ATTACHMENT A

MPW Stage 2 – TfNSW Second Response

¹ Some other intersections impacted by the Moorebank Precinct are part of discussions between SIMTA, Transport for NSW and NSW Roads and Maritime Services, relating to an agreed mitigation framework for the MPE and MPW Projects.
MPW Stage 2 Proposal - SIMTA TfNSW 2nd Response

SITE LAYOUT

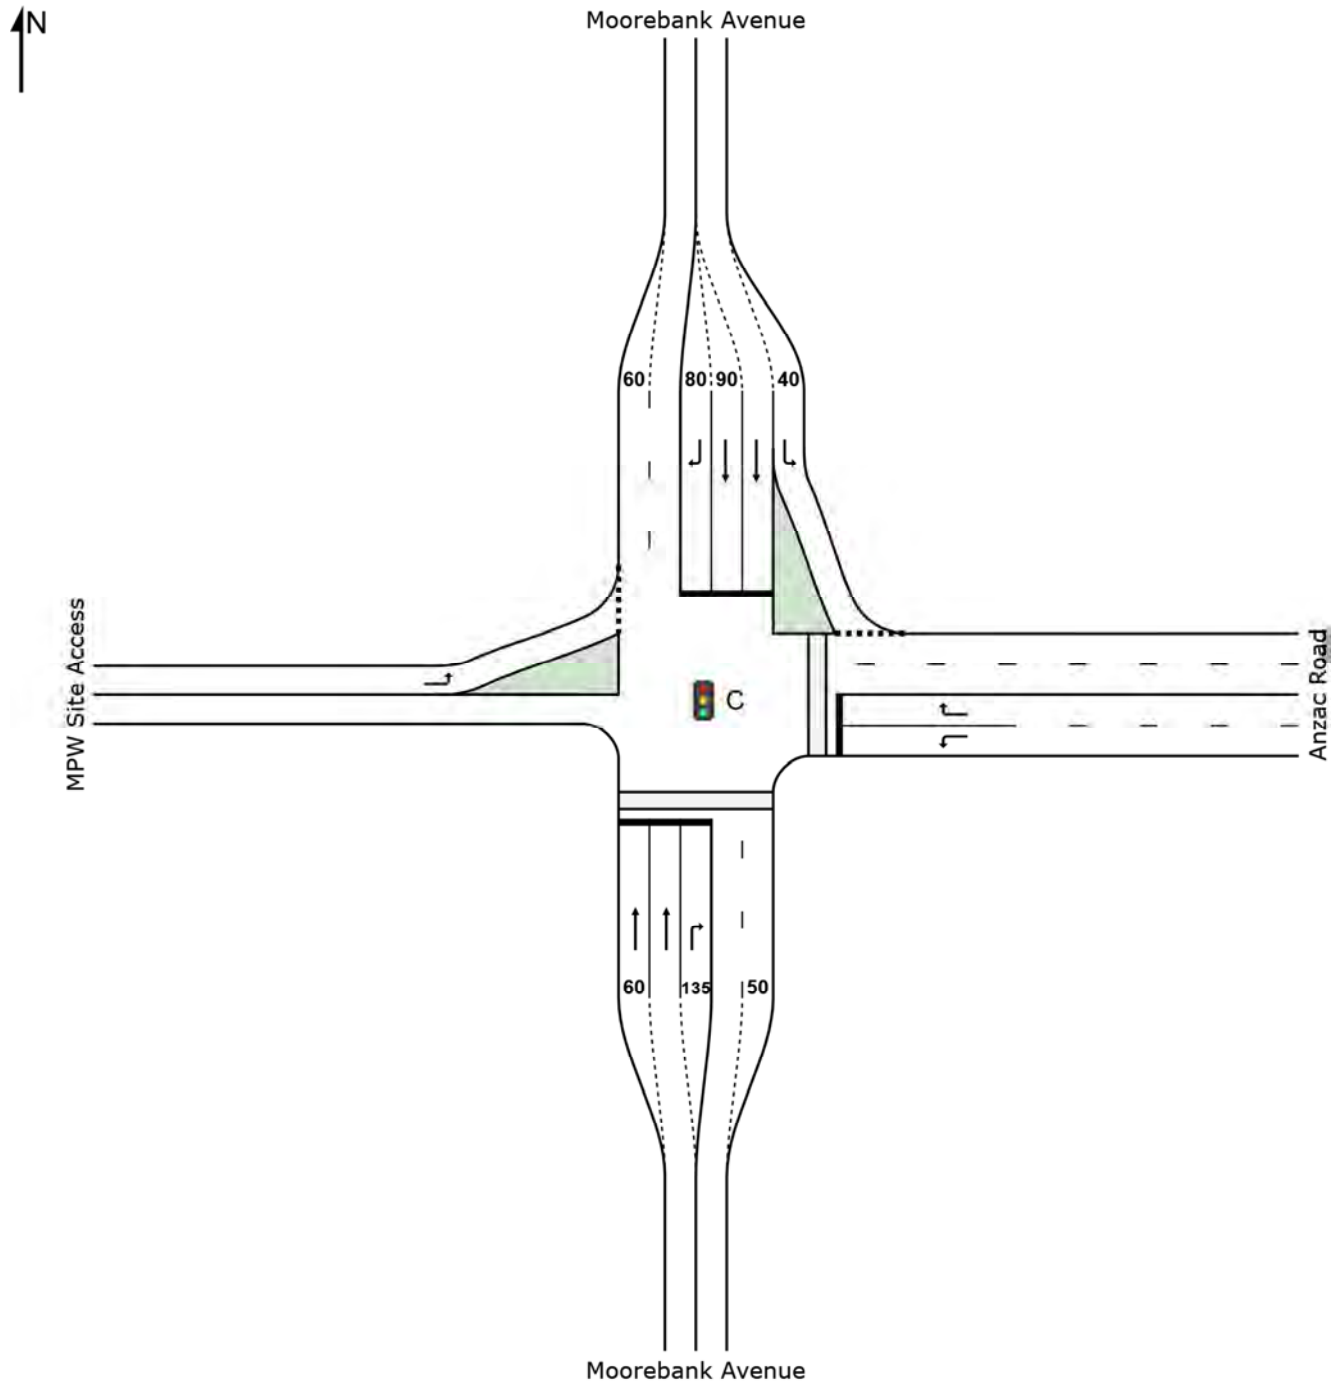
TfNSW Submission	SIMTA Response	Reference
	<ul style="list-style-type: none"> – One left turning slip lane onto Moorebank Avenue (southbound) • Moorebank Avenue (northbound): <ul style="list-style-type: none"> – Two right turning lanes onto Anzac Road (eastbound) – Two through lanes continuing on Moorebank Avenue (northbound) – One left turning slip lane onto the new access road (westbound). <p>The MPW Stage 2 Proposal also includes an associated upgrade to the Moorebank Avenue / Bapaume intersection with the final configuration to be the following:</p> <ul style="list-style-type: none"> • Moorebank Avenue would be reconfigured for no right turn onto Bapaume Road from Moorebank Avenue • Bapaume Road would be reconfigured for no right turn onto Moorebank Avenue from Bapaume Road • The reconfigured Bapaume Road would allow the following movements: <ul style="list-style-type: none"> – Inbound traffic to the ABB site would be directed to the new Moorebank Avenue/Anzac Road intersection (main MPW site entrance) – Northbound traffic out of the ABB site would use Bapaume Road or the new Moorebank Avenue/Anzac Road intersection (main MPW site entrance) – Southbound traffic out of the ABB site would use the new Moorebank Avenue/Anzac Road intersection (main MPW site entrance). <p>Additional intersections within the broader network, as identified in the Operational Traffic and Transport Impact Assessment (Appendix M of the EIS), also require improvements by Roads and Maritime to accommodate background growth. These intersections¹ include:</p> <ul style="list-style-type: none"> • M5 Motorway/Hume Highway • Moorebank Avenue/Newbridge Road • Moorebank Avenue/Heathcote Road • M5 Motorway/Heathcote Road.

TfNSW Submission	SIMTA Response	Reference
	<p>Recommended improvements to these intersections are suggested, however, as the Proposal does not worsen intersection performance, these improvements are not included as mitigation measures for the Proposal (refer to Appendix M of the EIS and Appendix C of the RtS).</p> <p>Overall, the upgrade of the Moorebank Avenue / Anzac Road intersection and the associated road network improvements to be undertaken by Roads and Maritime would result in an improvement to the road network during the operation of the MPW Stage 2 Proposal. In consideration of this, the MPW Stage 2 Proposal is, subject to the implementation of upgrades, not considered to exceed the capacity of the road network and is therefore consistent with the MPW Concept Approval.</p> <p>Further, Section 5.4.1 of the MPW Stage 2 EIS provided an assessment of the Proposal in consideration of the requirements of the <i>Liverpool Local Environmental Plan 2008</i> (Liverpool LEP 2008). In particular, this assessment considered the requirements of clause 7.36 of the Liverpool LEP 2008. In summary, the MPW Stage 2 Proposal complies with clause 7.36 of the Liverpool LEP 2008 in that it proposes an intermodal terminal, warehousing, rail connection and conservation area on areas shown in the Key site map (associated with this clause) and that the Proposal includes the provision of upgrades to the Moorebank Avenue/Anzac Road intersection.</p>
